Our ref. DOC17/254763-08
Sender's ref. SSD 7401

STANDARD POST & EMAIL
5 June 2017

Bettergrow Resource Recovery Facility, Wetherill Park, (SSD 7401) - Response to Notice of Exhibition

**Figure 3: Organics Receival & Processing Building and Food Depackaging Building (northern portion of site)**

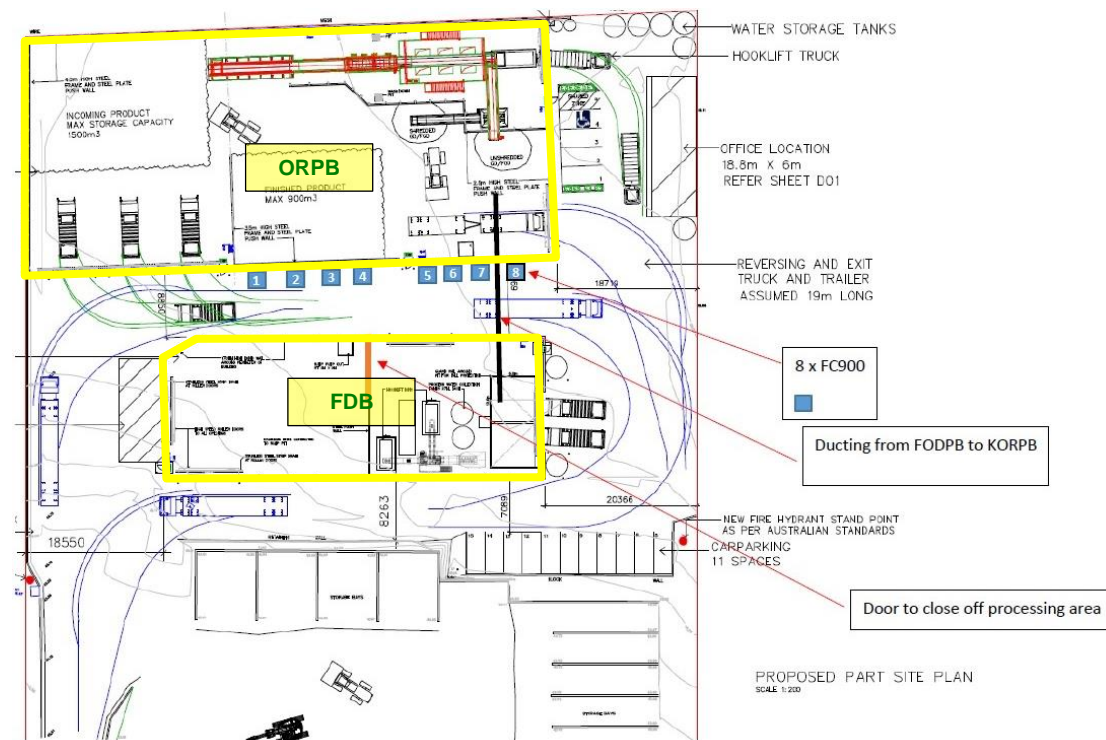
Page 15 of the odour assessment (Appendix 8) states that 'potentially odorous air from within the Food Depackaging Building will be ducted to the Organic Receival and Processing building where it will be mixed and treated by the carbon filtration unit to release into the atmosphere. However, the figures do not show the ducting or the stacks, are the 8 carbon filters enough to service two buildings.
